**A30 Chiverton to Carland Cross  
TR010026**

**8.12 POST HEARING SUBMISSIONS  
INCLUDING WRITTEN SUBMISSIONS  
OF ORAL CASE - ISH 3 ON WCH**

April 2019

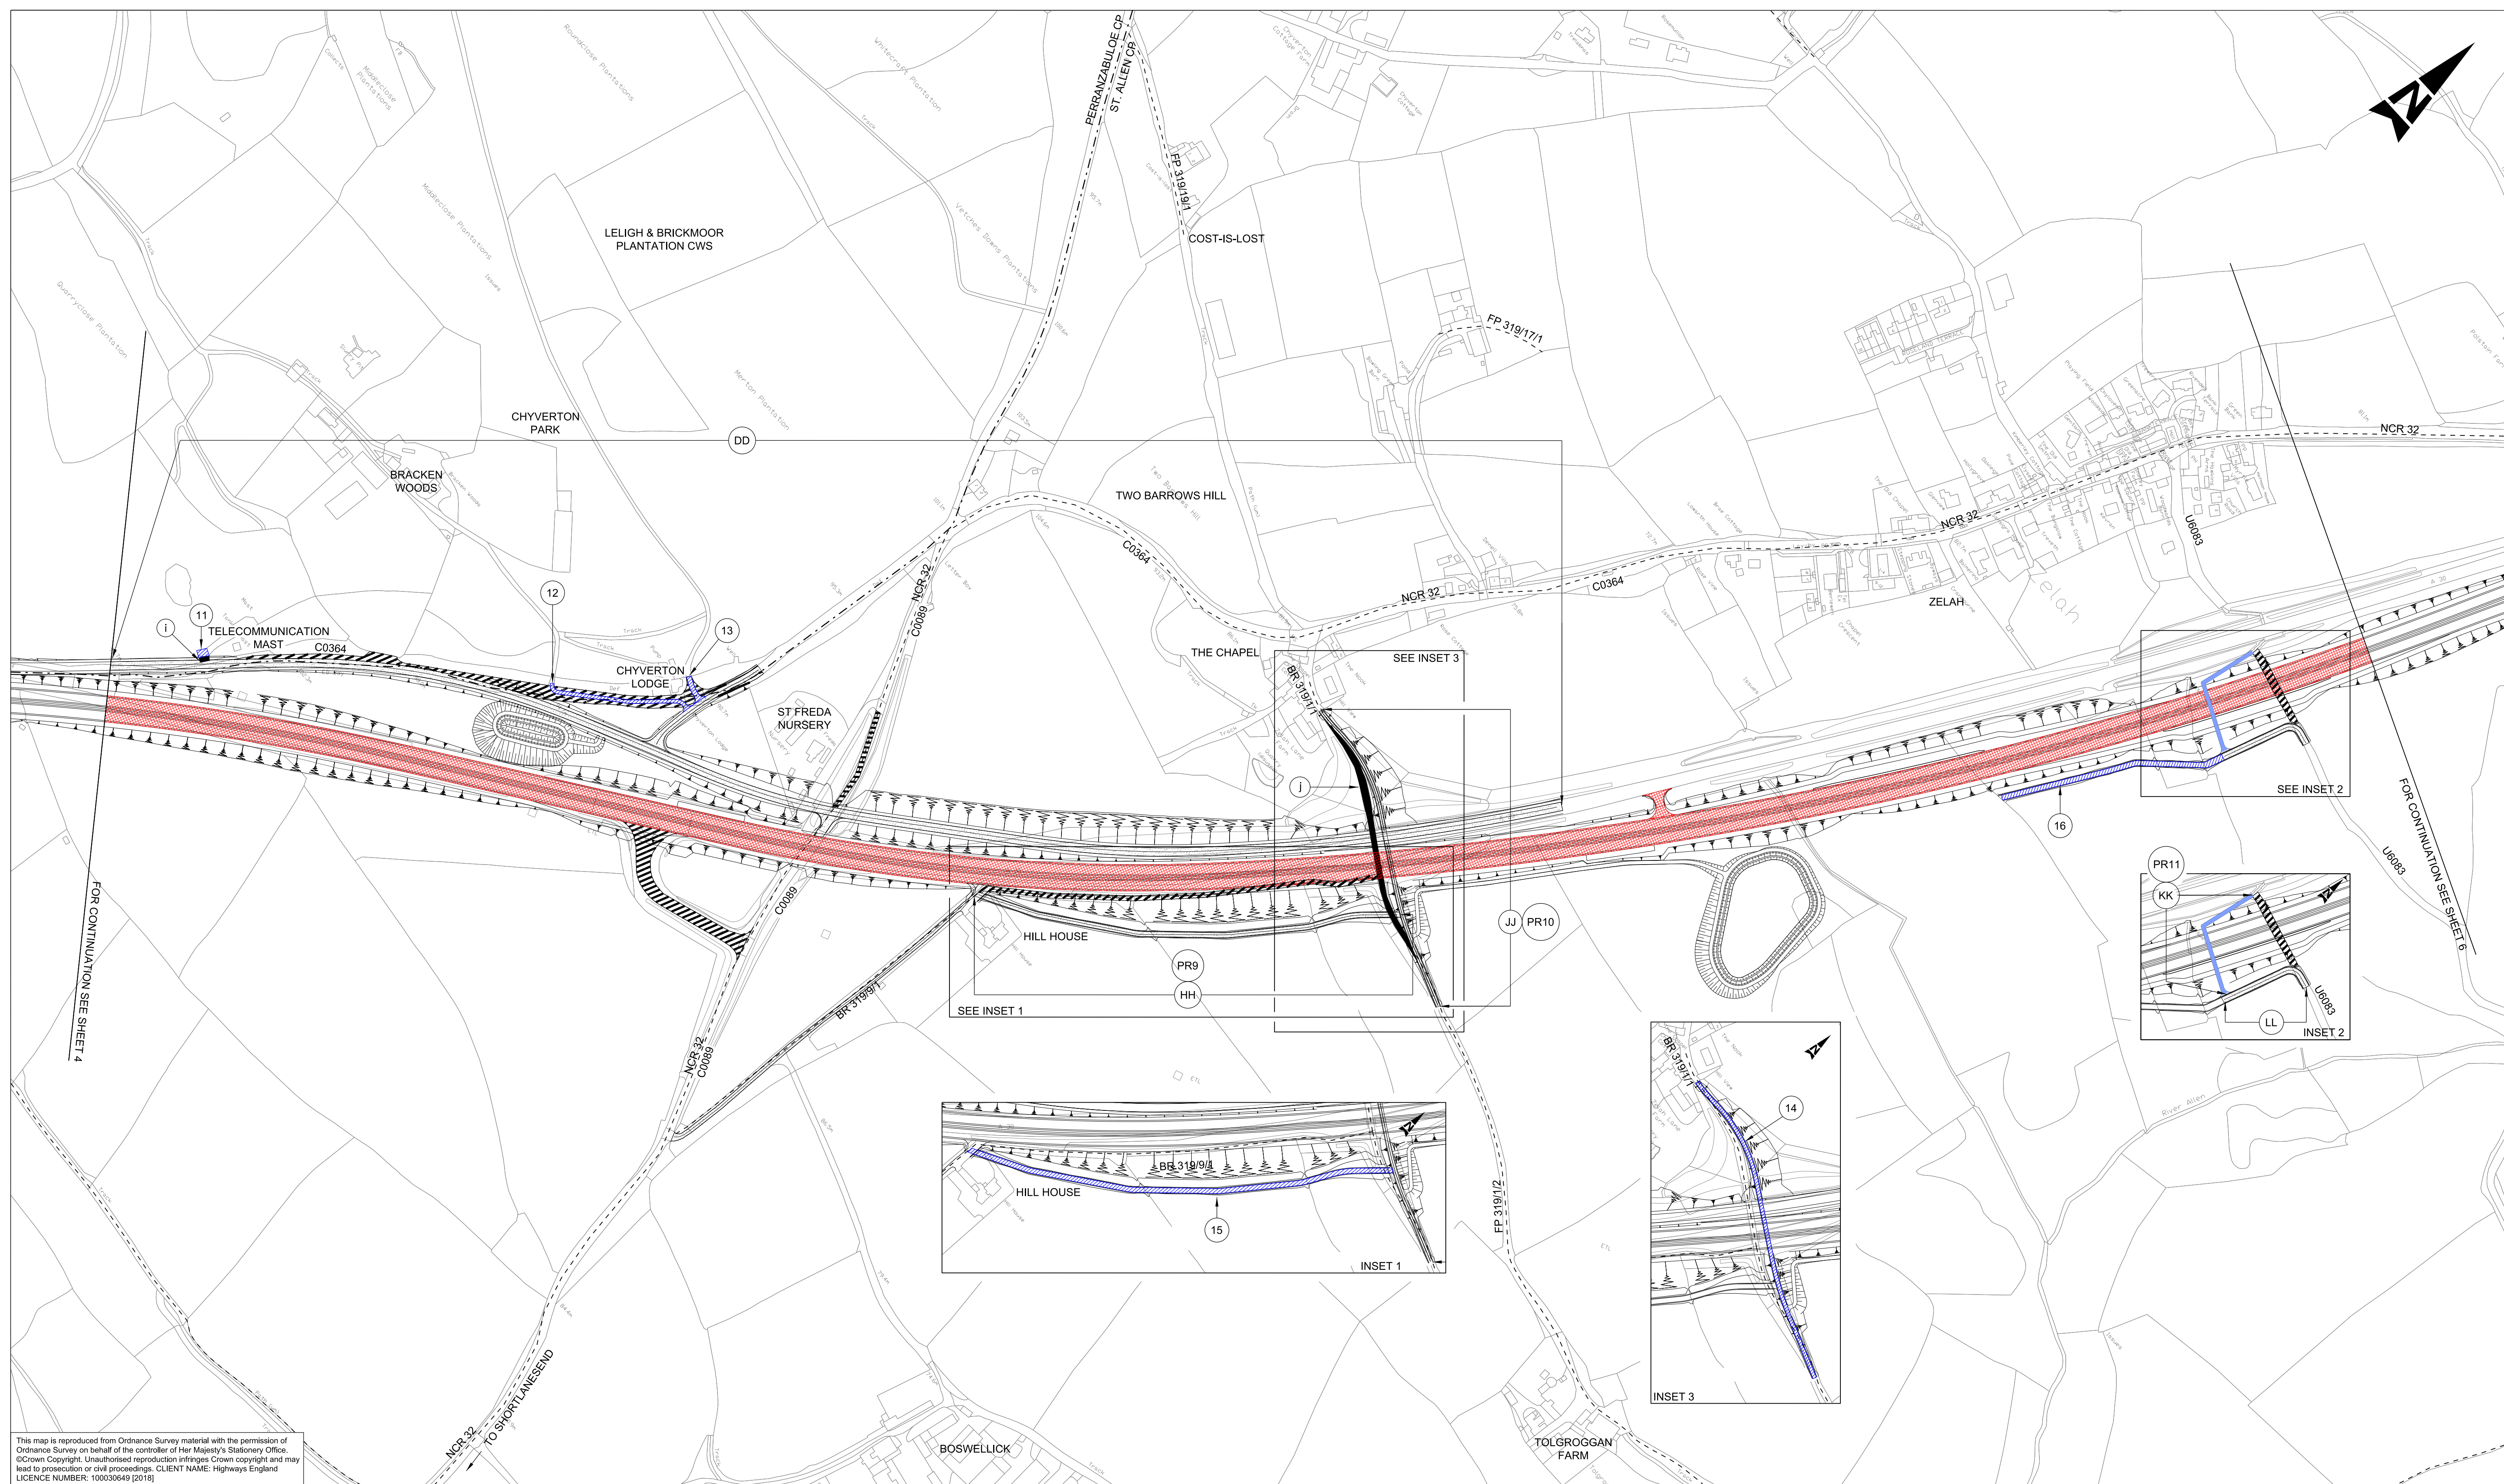
6d	<p>Any matters arising from the CC LIR [REP1-010] comment on Rights of Way and Access Plans Sheet 5-ref. JJ(PR10), asking whether the private means of access (16) could be changed to Public Bridleway and linked to JJ along south side of bypass to give a connection to the east from the underbridge.</p> <p>[Note that the directions 'east', 'south', etc, have been taken from the CC LIR and may require clarification]</p>	<p>Highways England provided a response to this in the <b>Comments on Local Impact Report</b> (Document Reference 8.5) [REP2-021] submitted at Deadline 2.</p> <p>The scheme is not impacting an existing Public Right of Way and therefore there is no need to mitigate an impact in this location.</p> <p>Private access (16) was requested by the landowner as a private access, so any public bridleway over this length would have to be separate and run parallel to it.</p> <p>There is insufficient land available within the scheme to provide a parallel bridleway to the private access and its extension through to the existing bridleway JJ.</p>

6e	<p>Any matters arising from the CC LIR [REP1-010] comment on Rights of Way and Access Plans Sheet 5- ref. LL (U6083), asking whether the historical gap in highway rights of the unclassified lane</p>	<p>Highways England provided a response to this in the <b>Comments on Local Impact Report</b> (Document Reference 8.5) [REP2-021] submitted at Deadline 2.</p>

Agenda Item No.	Agenda Item or matter raised during the hearing	Summary of Oral Submissions
	U6083, where it crosses the existing A30, could be dealt with by extending the footpath over the existing A30 to provide continuous link	<p>The new underpass and crossing of the new A30 will tie into the existing southern steps, with the existing steps and crossing of the existing A30 retained.</p> <p>Cornwall Council could extend the footpath over the existing crossing as part of their de-trunking works if considered necessary.</p> <p>This is an existing crossing that is not proposed to be changed as part of the proposed scheme / under the DCO.</p>
6f	Any matters arising from the request of St Allen Parish Council [REP1-027] that the tunnel through Church Lane should be under both the new and the existing A30, in line with each other to create a continuous route.	Highways England considered this matter in response to Agenda Item 6c above, which sets out how the numerical and site assessment of the existing crossing, taking into account the reduced traffic levels on this section of the existing A30, demonstrates that there is not a requirement for a grade-separated crossing of the existing route.
